Submission No.			048		
Organisation Name or Name of Submitter			College and Wainsfort Residents Association		
Item No.	Section Ref.	Page No.	Observation Statement	TII Response	
314724: Estuary through Swords, Dublin Airport, Ballymun, Glasnevin and City Centre to Charlemont, Co. Dublin					
1	Statement	1	The College and Wainsfort Residents Association submission wholly relates to that portion of the proposed Metro Link beyond the station located at St Stephen's Green East. For the avoidance of any doubt we are fully supportive of the project from Estuary to St Stephen's Green, which we consider is long overdue.	TII notes and appreciates the observer's overall endorsement of the MetroLink Project with the exception of the section of the alignment south of the proposed St Stephen's Green Station. We have reviewed the observer's submission and responded to the observations made below.	
2	Submission	2	We submit that Bord Pleanala should defer the authorisation of the section of MetroLink beyond the St Stephen's Green station, other than to create a turning section similar in length to that which is currently proposed for Manders Terrace. Reasons as follows: 1 . Failure to consider an a

TUNNEL ALIGNMENT
SAINT STEPHEN'S GREEN – CHARLEMONT
RO APPLICATION VS DEEPER VERTICAL ALIGNMENT OPTION

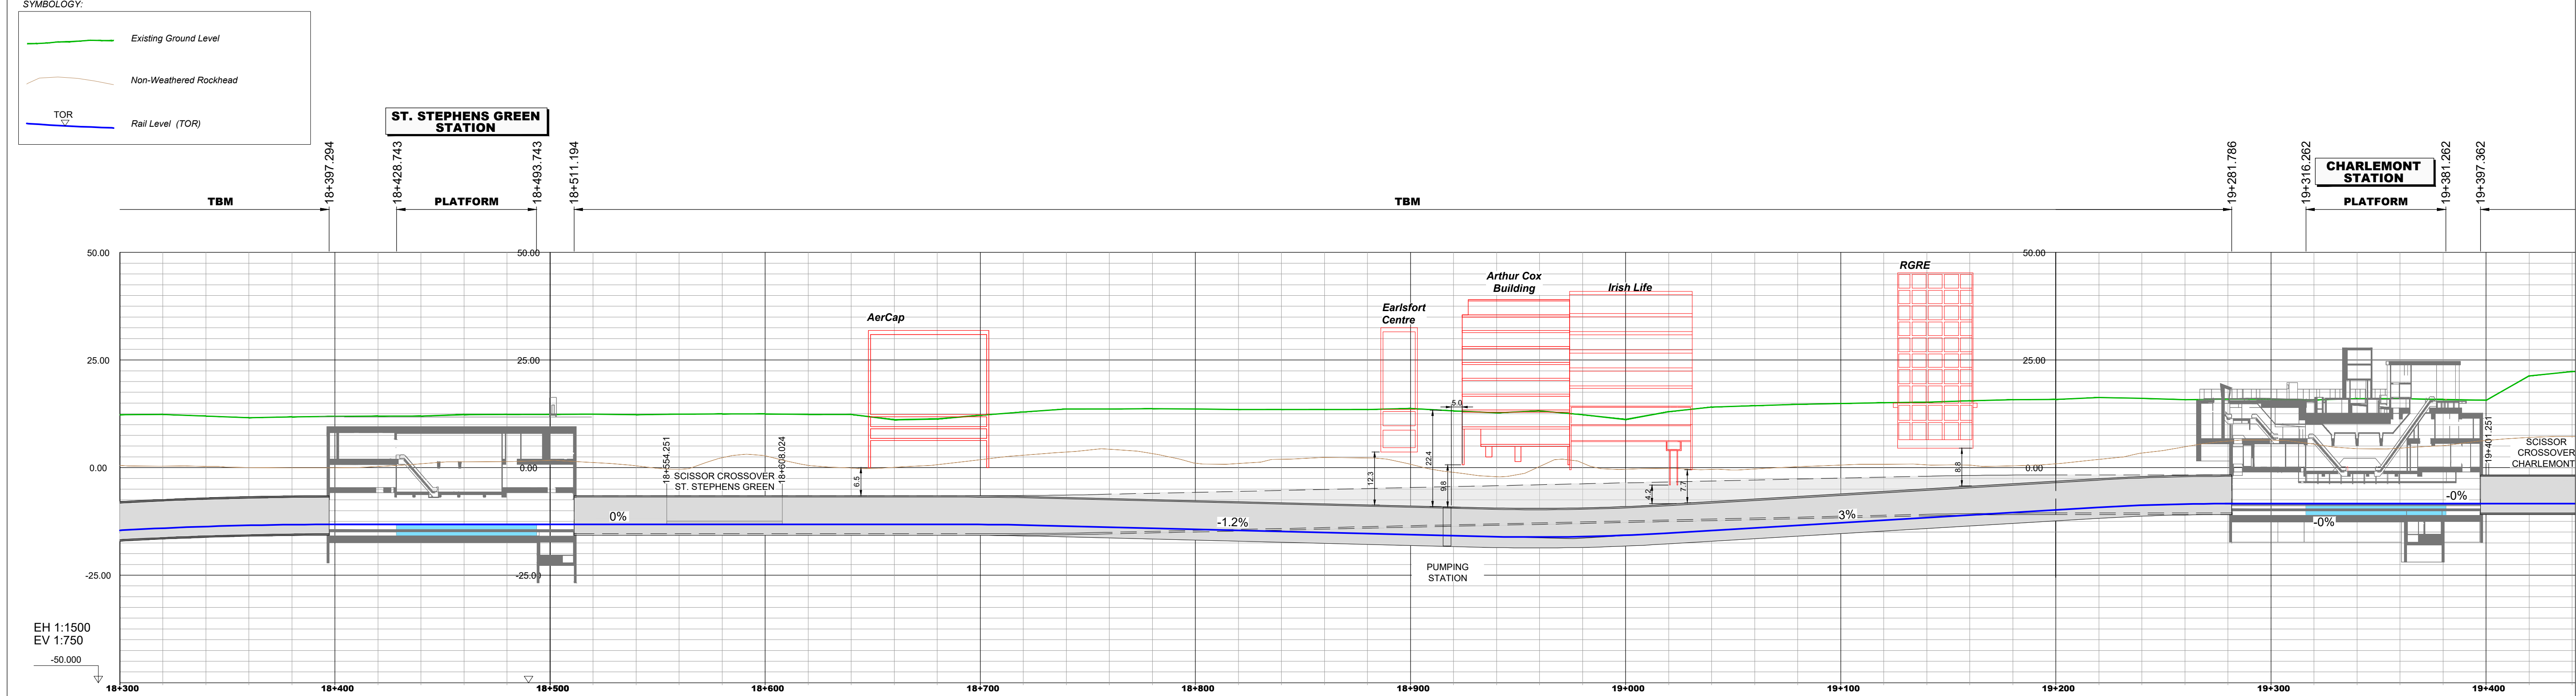
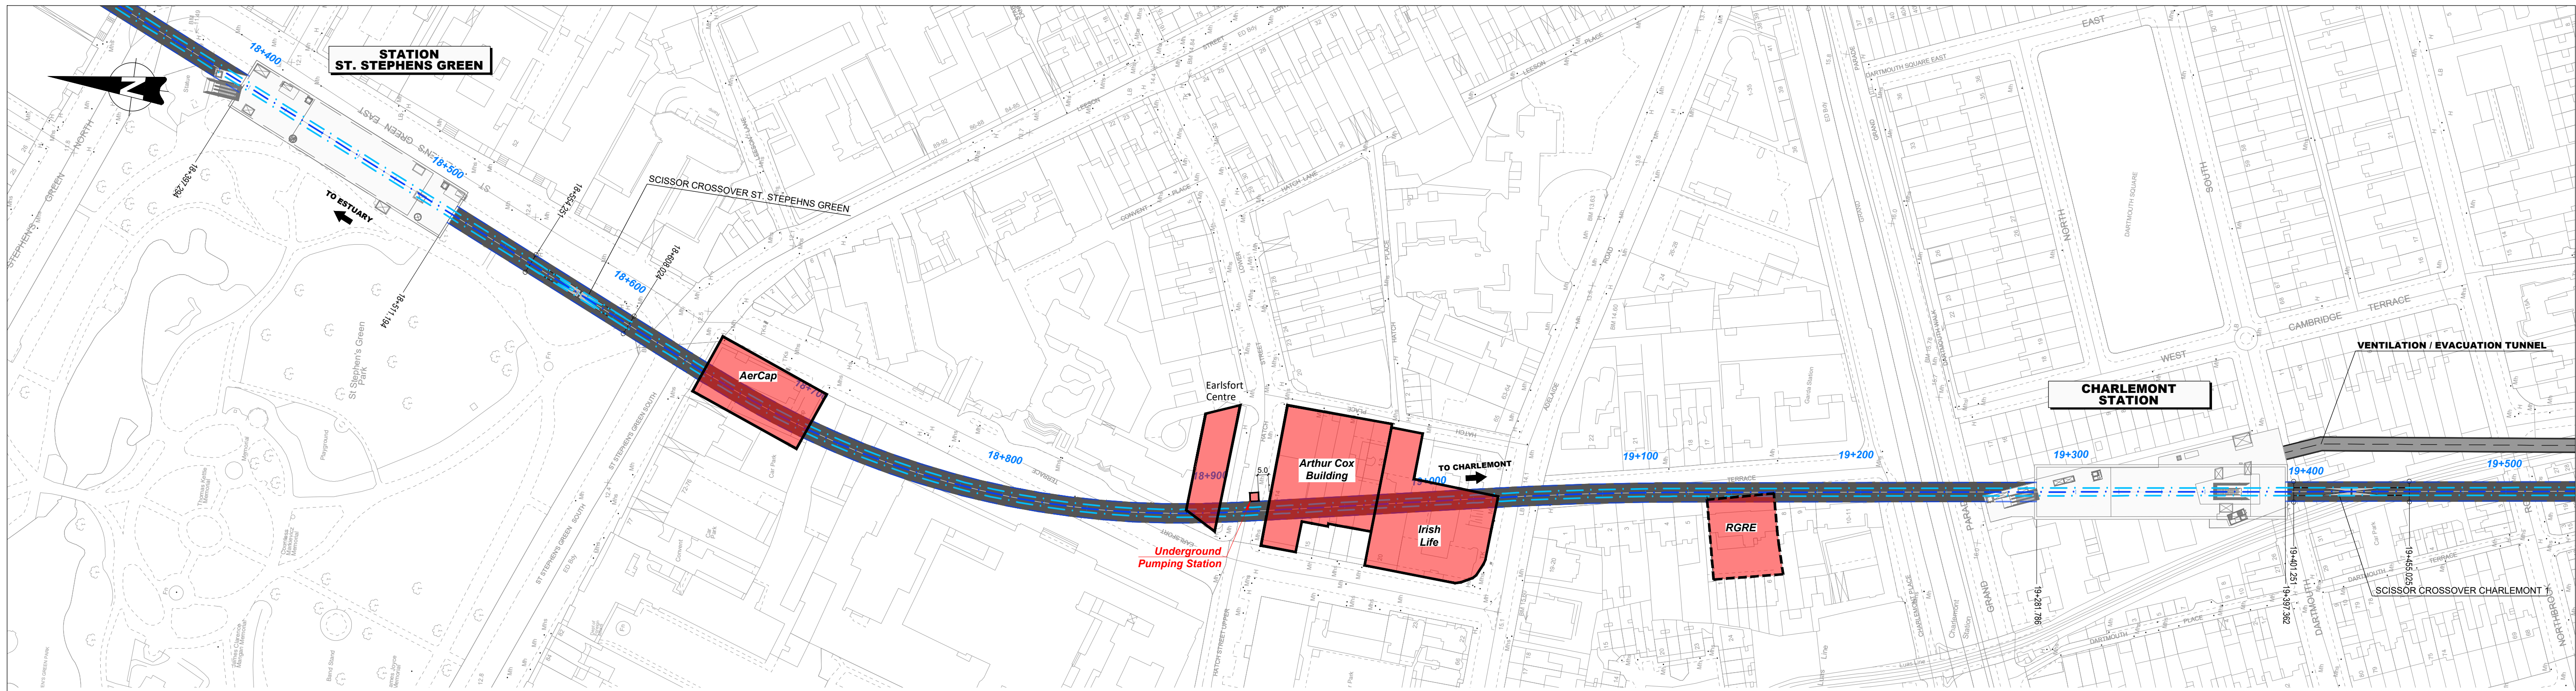
7	4. Poor access to Charlemont from Rathmines Road.	4	<p>As we note above there will be numerous buses (33 per hour peak in each direction) on Rathmines Road once BusConnects is implemented. Therefore, we think it is very likely that a lot of passengers will alight at Portobello Bridge and walk across to the MetroLink, particularly if they want to access parts of the North city or the airport, quite likely with luggage.</p> <p>There is no thought given in the TII plans to the route such people will walk/take, but we suspect it would be on both sides of Canal Road and Grand Parade. The Railway Order plan contains no proposals for a proper infrastructure to facilitate this.</p> <p>However, the most obvious solution to this problem is to have a terminus closer to Rathmines Road.</p> <p>We submits that Bord Pleanala should defer the authorisation of the section of MetroLink beyond the St Stephen's Green station, other than to create a turning section similar in length to that which is currently proposed for Manders Terrace.</p> <p>It would be premature to constrain the available options by allowing MetroLink to proceed beyond St Stephens Green to Charlemont / Manders Terrace.</p> <p>“What had the outside reviewers have to say about continuing to Charlemont/Manders Terrace?”</p> <p>Jaspers: "The connection to Ranelagh could feasibly be deferred until there is clarity on the future of the Green Line (subject to an improved understanding of how this could physically be delivered in a scenario with Metro operational)"</p>	<p>The scope of the MetroLink project does not include the improvement or modification of the wider transport network.</p> <p>The above responses explain why TII does not consider it is correct or appropriate that the MetroLink alignment south of St Stephen's Green should be omitted, and also demonstrates why the proposed Charlemont Station has been selected by TII as the preferred interchange with the Luas Green Line.</p> <p>A scheme which terminates at St Stephen's Green would not be consistent with the Transport Strategy for Greater Dublin Area (2022-2042). In addition any decision to terminate the scheme at St Stephen's Green will significantly impact on the overall viability and benefits of scheme.</p>

Figure 5-14: SSG East Surface Layout

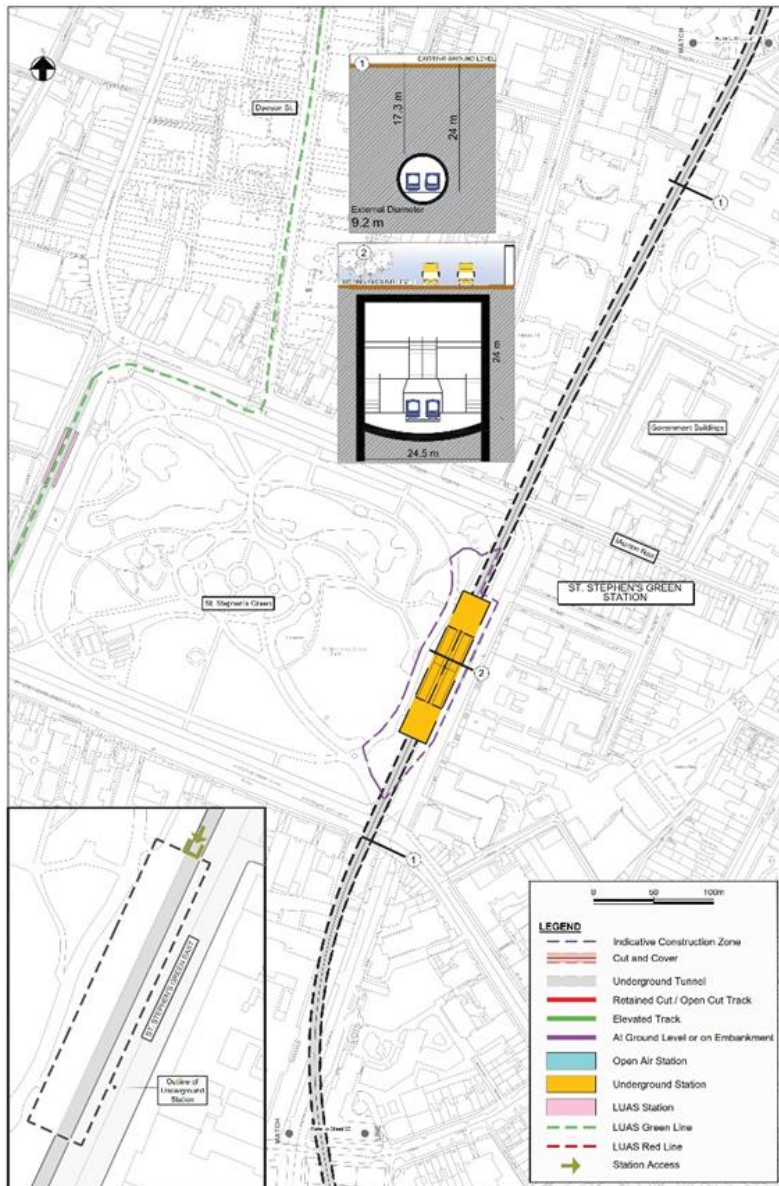
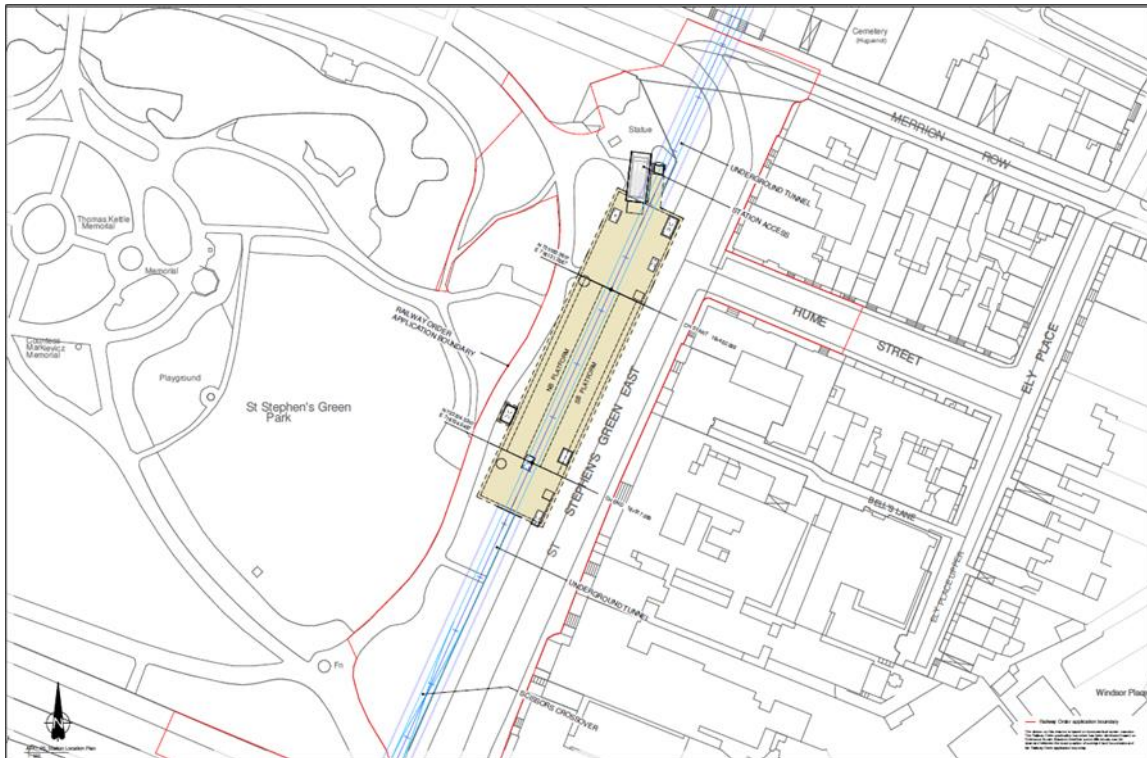
3	1. Failure to consider an alternative routing of the terminus towards Rathmines:	2	We would submit that the Rathmines or Portobello area would be a far more suitable location for a terminus but TII has wholly failed to consider this. This became relevant once the destination for a southern terminus was to be in or in the vicinity of the south inner city, rather than Sandyford.	<p>The reasons for proposing a station at Charlemont are explained below.</p> <p>The connection from St Stephens Green to Charlemont / Ranelagh is supported by the previous Transport Strategy for Greater Dublin Area (2016-2035) and the current Transport Strategy for Greater Dublin Area (2022-2042). The latter considers a range of options for the onward extension of MetroLink to meet the demand for travel over the period of the strategy. This includes consideration of the need for the upgrade of the Luas Green Line to the Metro with a Metro extension to Dublin south west, south or south east. Whilst the strategy envisages that further extensions will be delivered after 2042, a MetroLink which terminates at Charlemont allows for the possible extension of the Metro in all the above directions.</p> <p>The proximity of the Metro to the Luas line at Charlemont provides for a positive customer experience for all users with short interchange distance and due to the proximity, clear wayfinding and high visibility of the interchange. The interchange arrangements at Charlemont provide for significantly better interchange arrangements compared to an alternative interchange at St Stephen's Green Station. Passengers wishing to interchange between Luas and the Metro at an alternative St Stephen's Green terminus would face a 500m-walk along a route either through St Stephen's Green park or along the footpath north of the park, which adds significantly to the time for interchange and therefore the overall journey time for passengers and a less positive customer experience for all interchange users. This passenger experience would be reduced further for those with mobility or visual impairments as well as those travelling to/from the airport with luggage.</p> <p>The section of MetroLink route between St Stephen's Green and Charlemont Stations contributes significantly to the overall benefits of the scheme. It serves a significant area of the south city of Dublin and offers enhanced access from the local area to the city centre and a direct connection to Dublin Airport. It serves key trip attractors including residential areas and offices / workplace locations, with high passenger boarding and alighting figures in the peak hours. During the morning peak, at Charlemont Station the flows include 1,800 passengers alighting, 2,300 boarding and 1,229 passengers alighting, 2,276 boarding during the evening peak. The passenger numbers contribute significantly to the overall benefits of the scheme and the effect of these benefits outweigh the additional costs that are associated with the delivery and operation of the section from St Stephen's Green to Charlemont Station. Further information is available in Chapter 7: Consideration of the Alternatives, section 7.7.8 MetroLink Southern Terminus Location.</p>

(3) continued	<p>The location of the interchange at Charlemont does not preclude onward extension south. An interchange at Charlemont is supported by policy including the Dublin City Development Plan 2022 - 2028 and the Transport Strategy for the Greater Dublin Area. As noted by the GDA Transport Strategy 2022-2042, section 12.3.2, "Charlemont offers the optimal location for the primary interchange with the Green Line in response to growing demand in the longer term and is an appropriate location to facilitate any potential future metro extensions to serve the south west, south or south east of the city region should sufficient demand arise."</p> <p>By extending MetroLink to Charlemont it provides for future proofing of the Green Line, bypassing the capacity constrained Luas on-street running section, and ensures potential future connectivity options are enabled, either to the Green Line or for extensions of the Metro.</p> <p>The Charlemont Station interchange provides for increased passenger utilisation of the MetroLink system, thereby increasing the benefits delivered by the Project, reflected by an improved Project Benefit Cost Ration (BCR).</p> <p>TII would further note that the GDA Transport Strategy 2022-2042 (published in January 2023), section 12.3.8 Additional Luas Lines Post-2042, states that the analysis undertaken for the Transport Strategy indicates that a number of corridors in the GDA will, in the longer term, generate travel demand above that which can be catered for by higher capacity bus systems and are likely to require upgrading to light rail in the period after 2042. The planning and design work associated with this longer term framework can commence during the strategy period.</p> <p>Future Metro services to the south of Charlemont do not form part of the Metrolink scheme as presented under the Railway Order. TII's role is to deliver Metrolink as supported by the Transport Strategy for Greater Dublin Area (2022-2042) and Dublin City Development Plan 2022-2028. The connection from St Stephens Green to Charlemont / Ranelagh is supported by the current Transport Strategy. The Transport Strategies were prepared by the National Transport Authority, scrutinised by the Joint Oireachtas Committee on Transport, and approved by the Minister for Transport. It notes in section 12.3.2, "Charlemont offers the optimal location for the primary interchange with the Green Line in response to growing demand in the longer term and is an appropriate location to facilitate any potential future metro extensions to serve the southwest, south or southeast of the city region should sufficient demand arise "</p>
